Our ref: AF1231-L2
13 August 2026

Application number: 2025/70/92070/W, Airfield Quarry, Crosland Hill, Huddersfield, HD4 7AB

With regard to the above Section 73 Application (Town and Country Planning Act 1990) regarding Airfield Quarry. The Applicant is Johnsons Wellfield Limited and Bright & Associates (B&A) are acting as the Agent in this matter.

I have addressed each matter below and also enclose two revised plans to confirm relative heights of the bunds. These are: AF1231 D13v2 Rev A Cross Sections which updates the earlier submitted plan AF1231-D13v1 and AF1231-D9v7 Rev B Proposed Working Scheme_Plan P4 Rev B which is an updated version of the earlier submitted Plan P4 Rev A.

Drawing:
**AF1231-D13
(Rev A)**

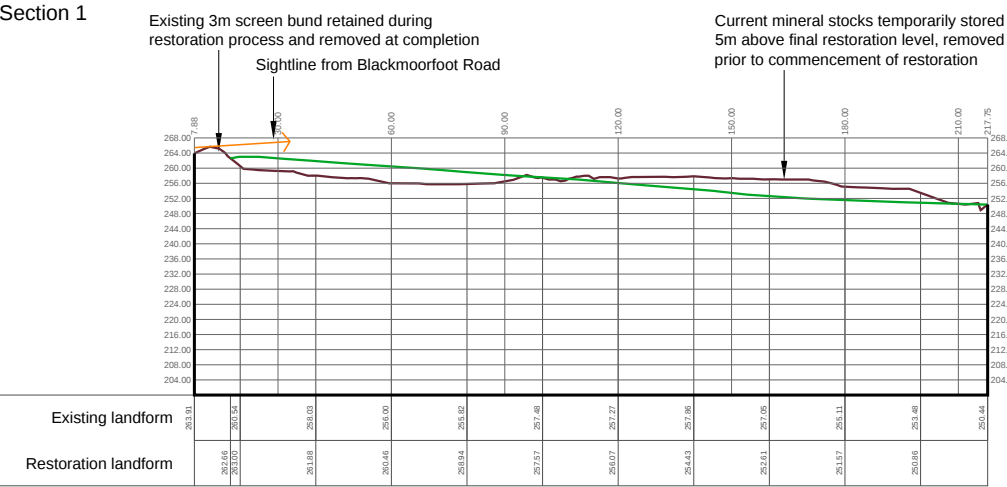
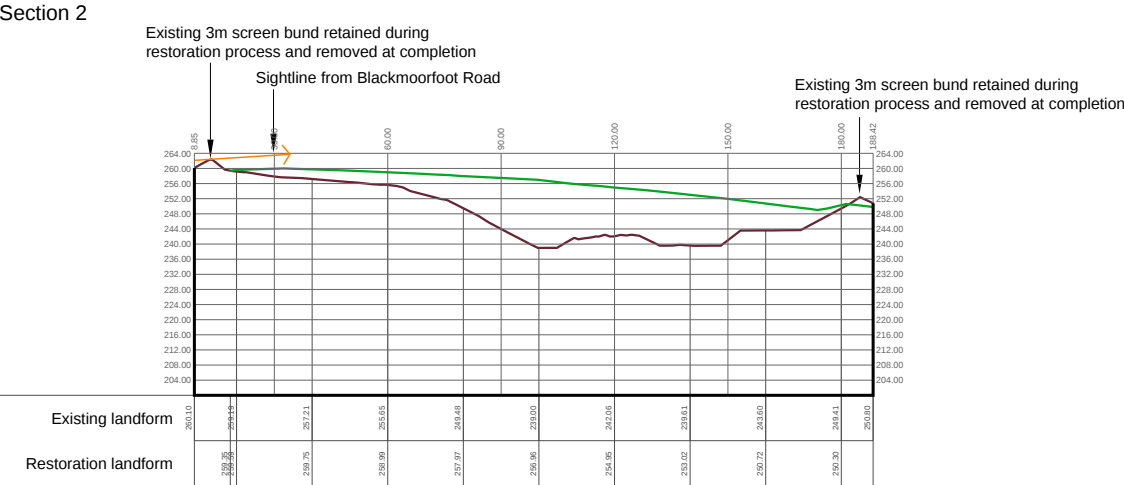
On the 29th July 2026 you requested specific detail by email with regard to Condition 14. Your email listed a need to understand the heights of operational stockpiles and the comparative heights of the screen bunds. You provided a list of information that required clarification, namely:

- the maximum operational height (AOD) of all proposed overburden, mineral and mineral waste stockpiles;
- the maximum height of each stockpile above existing ground level (metres);
- the crest level (AOD) of the perimeter screening bunds; and
- the relationship between the proposed stockpiles and the screening bunds to enable a direct comparison.

Most stocked material has now been removed, however for the purpose of clarity the highest stoked material as shown on Section 1 is 261mAOD. Future levels (AOD) will be below this.

Generally speaking, the material stored within the site and as illustrated is a maximum of 5m in overall height. The existing screen bunds around the periphery are 3m in height. These levels have been found to be adequate in screening most workings within the site due to a combination of the relative heights, sloping terrain and distance. In effect the boundary screen bunds are closer to the viewer thus achieving a good degree of screen.

As noted above, the screen bunds are 3m in overall height and follow the eastern, northern and western boundary and follow the natural ground levels and contours thus it will have a variable crest level (AOD). It is proposed to retain these bunds until all other working and restoration works have taken place and the native soils contained in the screen bunds will then be utilised to achieve final soil cover as per the restoration masterplan.

The overall relationship is best conveyed by refence to the cross sections. Height information has been added to the illustrations as well as projected sightlines from the adjacent road network.
